24/03259/F – Holding Objection further information required.

**Location: Land Adjacent to Symmetry Park, Bicester**

client			
Tritax Big Box Developments			
project title			
Symmetry Park Bicester, Phase 3			
drawing title			
Breeding Bird Survey 2024			
date	27 NOVEMBER 2024	drawn by	PDr
drawing number	edp7480_d020b	checked	NDo
scale	1:2,250 @ A3	QA	DJo

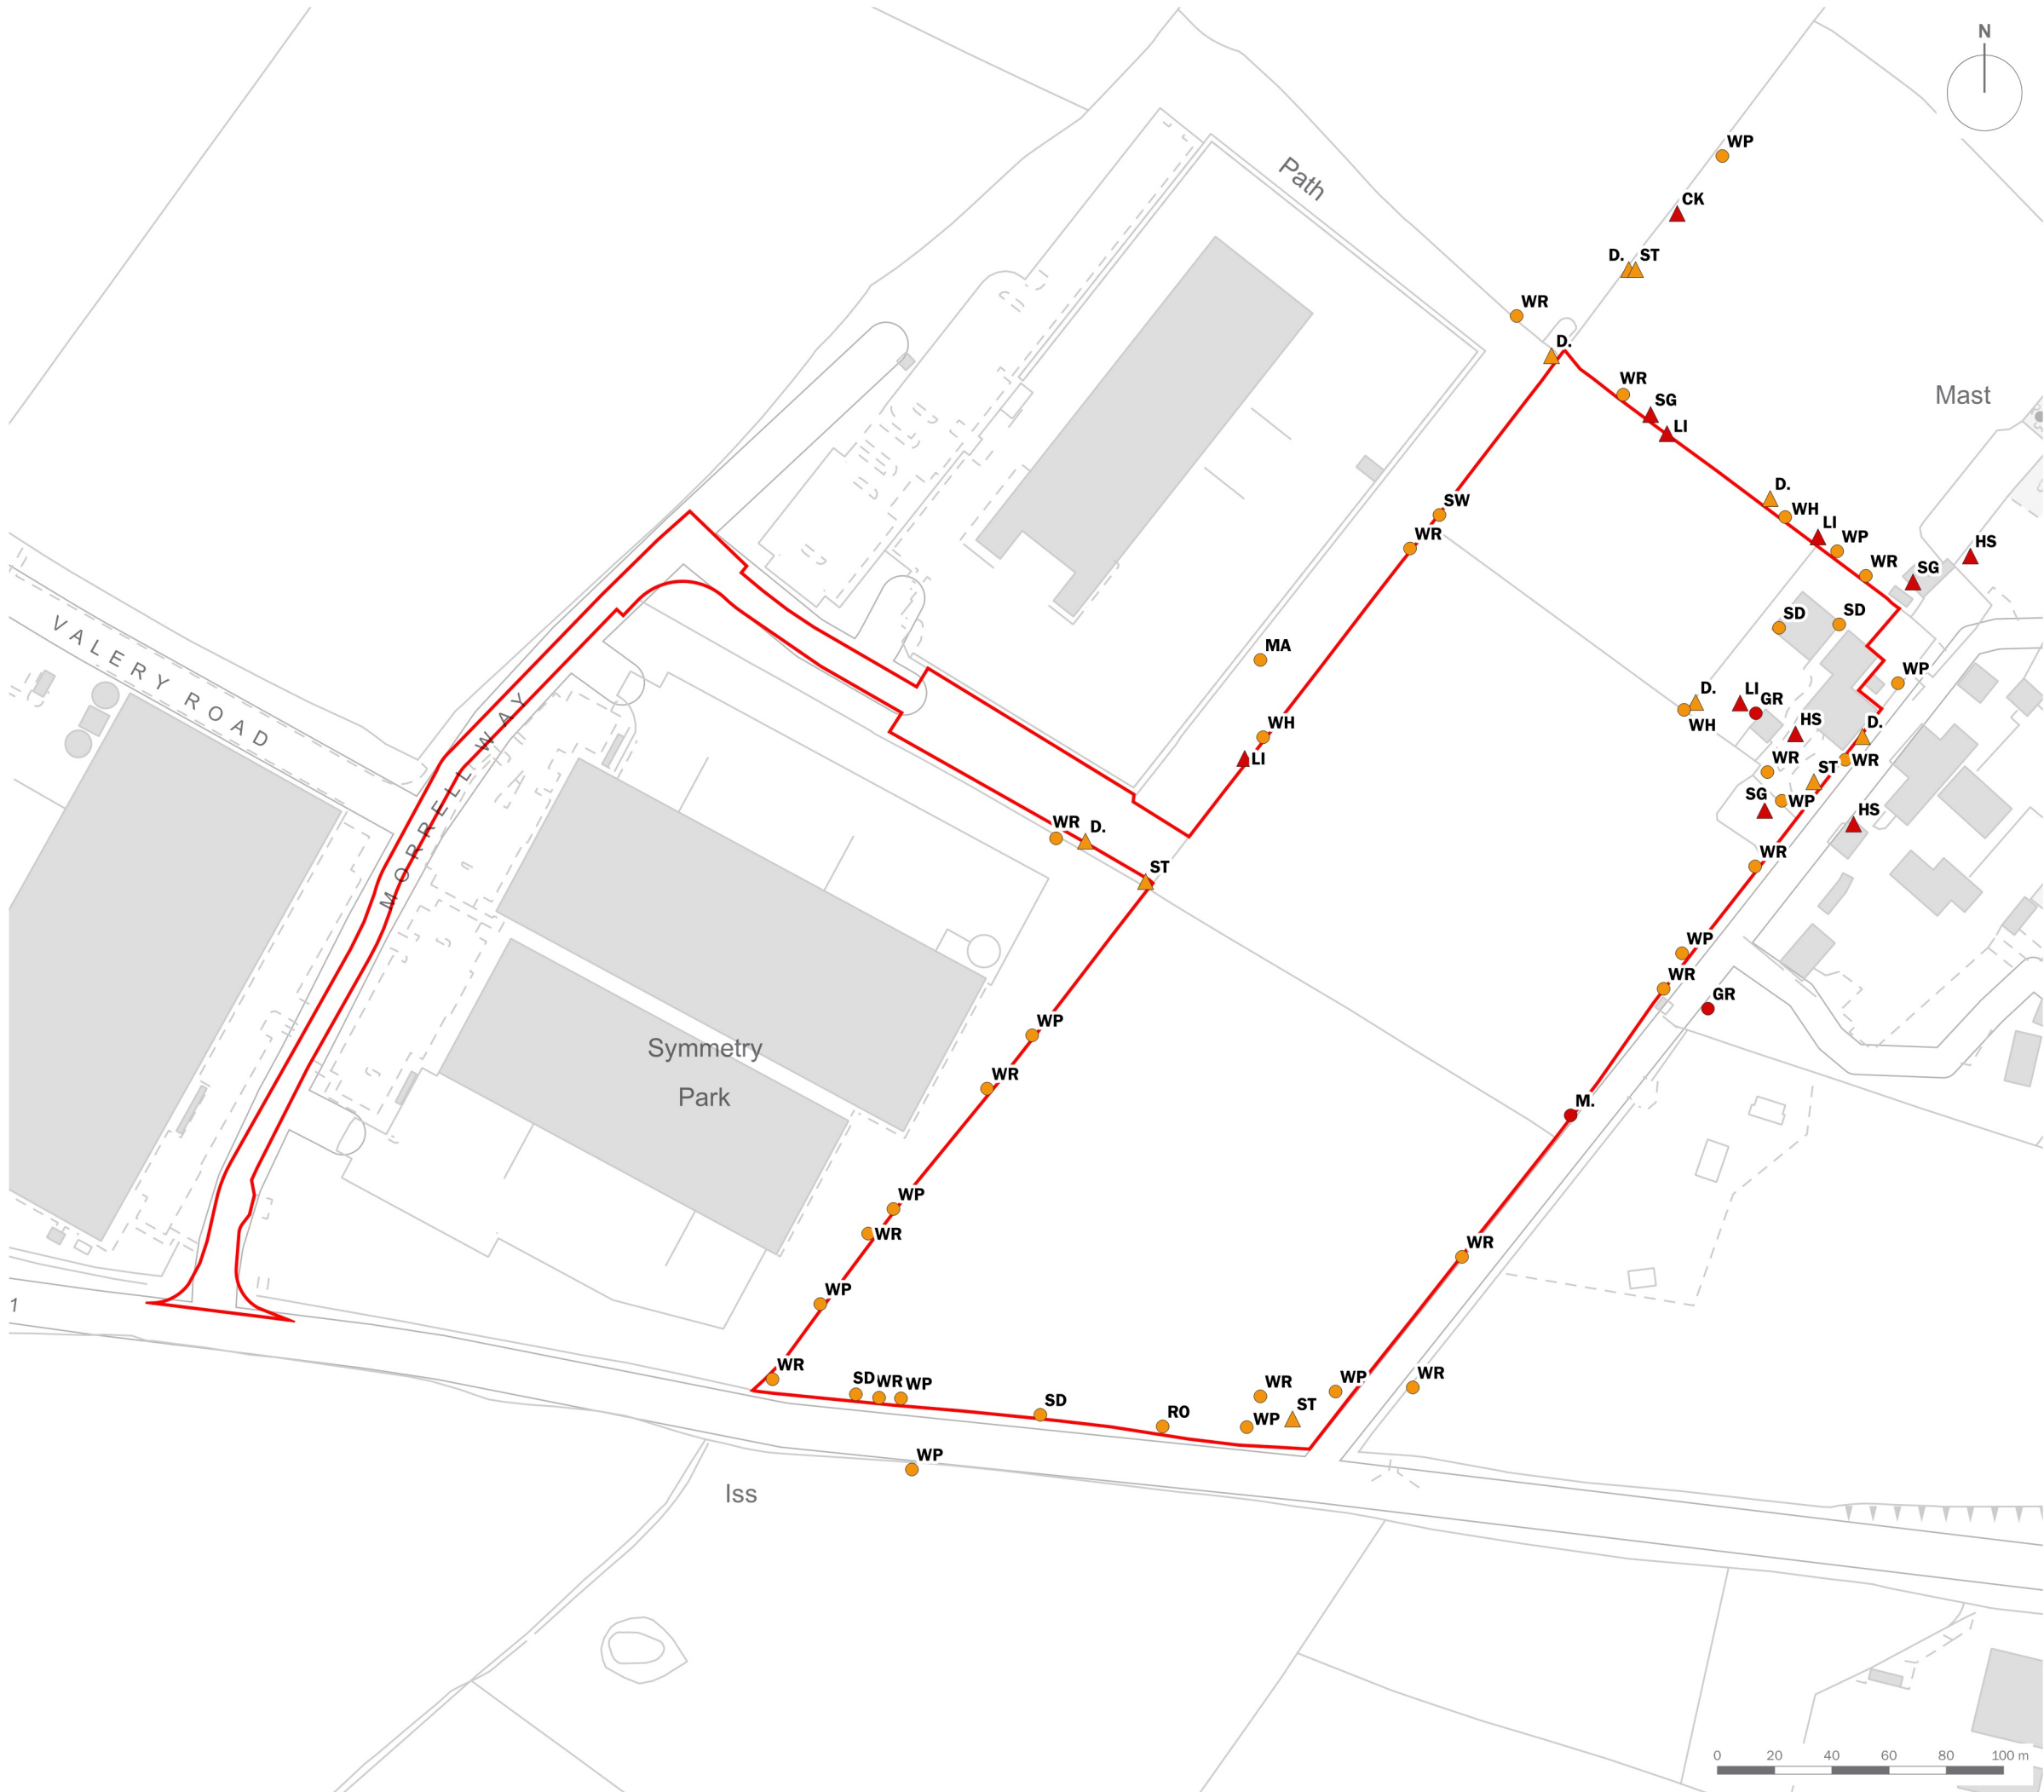
CIEEM the governing body for ecologists lists Bird Survey Guidelines website as the appropriate guidelines for breeding bird survey guidelines (see [Bird Survey Guidelines for assessing ecological impacts | CIEEM](#) and [Survey methodology | Bird Survey Guidelines](#)). While that guidance lists 6 visits, it is widely accepted that this can be lowered to 4 visits for farmland habitats, and only increased to 6 visits if priority species are breeding onsite.

Although two seasons of data is available I have concerns over the robustness of the assessment in relation to losing the ridge and furrow field in relation to farmland birds especially with such cumulative impact over the years in this location.

client			
Tritax Big Box Developments			
project title			
Symmetry Park Bicester, Phase 3			
drawing title			
Bat Survey			
date	27 NOVEMBER 2024	drawn by	GYo
drawing number	edp7480_d009b	checked	NDo
scale	1:2,000 @ A3	QA	DJo

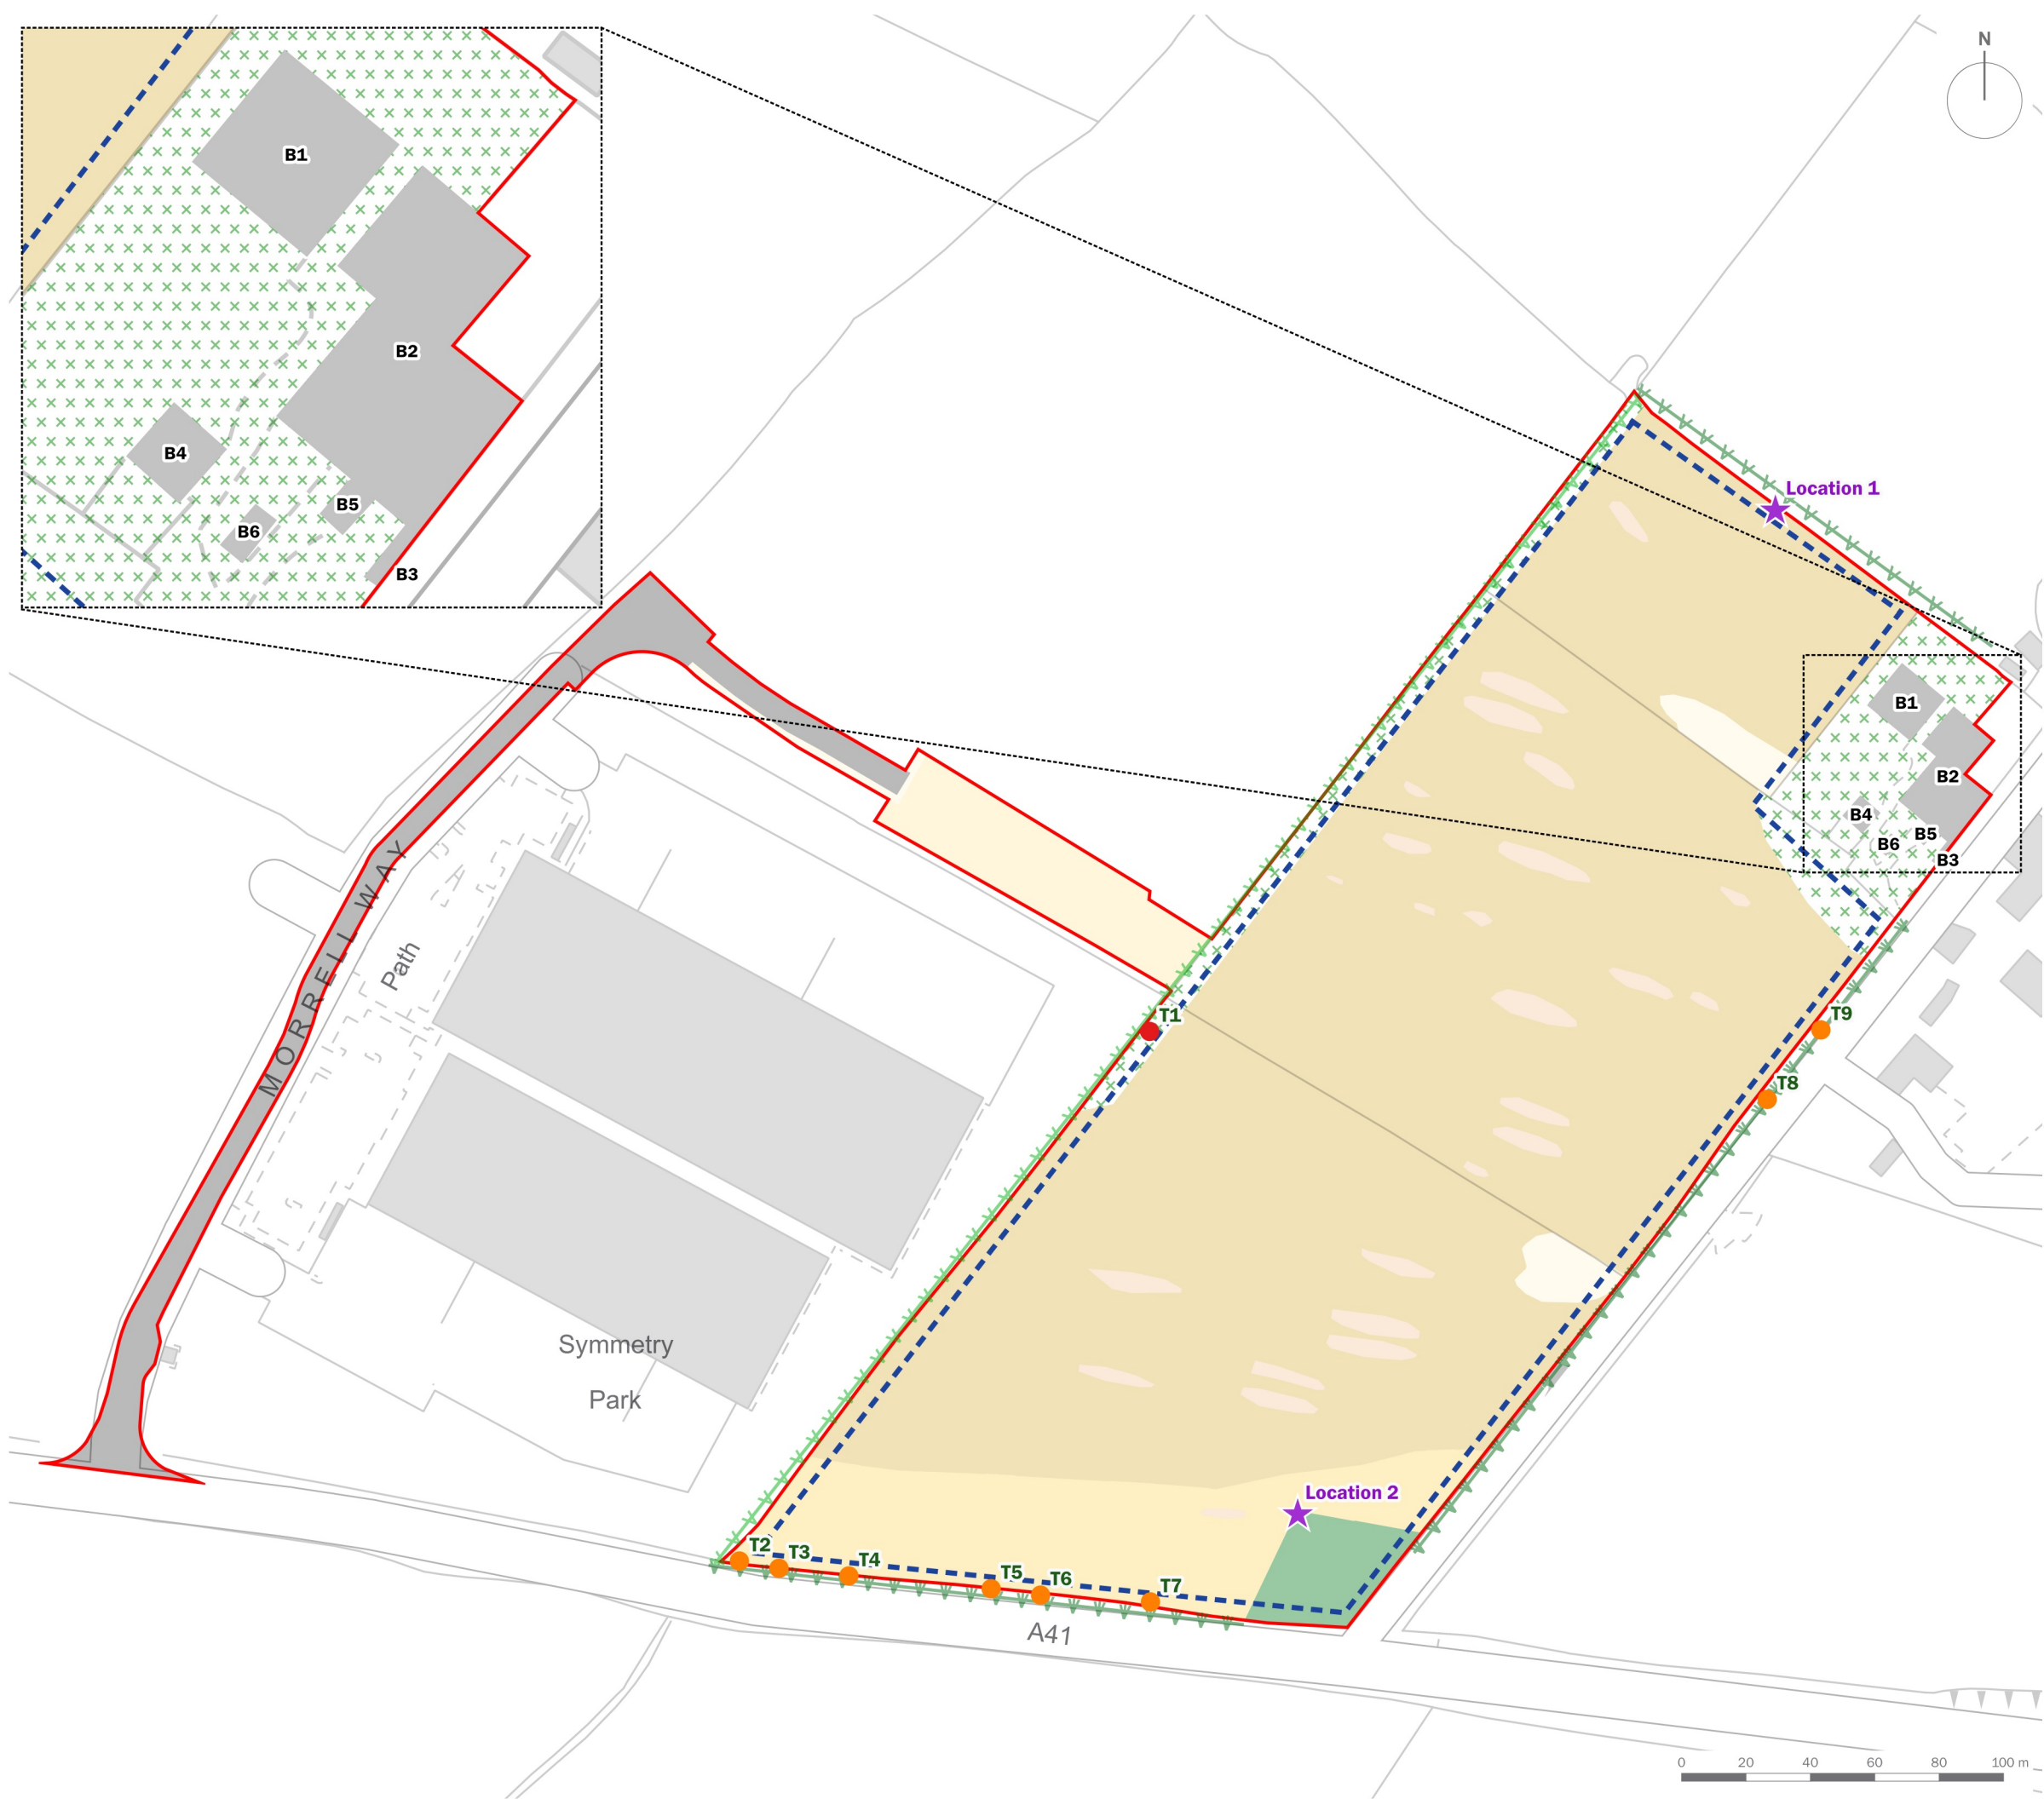
Bat Conservation Trust Guidelines which were updated in 2023 require static detectors to be deployed monthly between April and October for moderate suitability sites. Please can justification be provided as to deviation from survey guidelines despite confirmation of adherence to guidelines in the report.
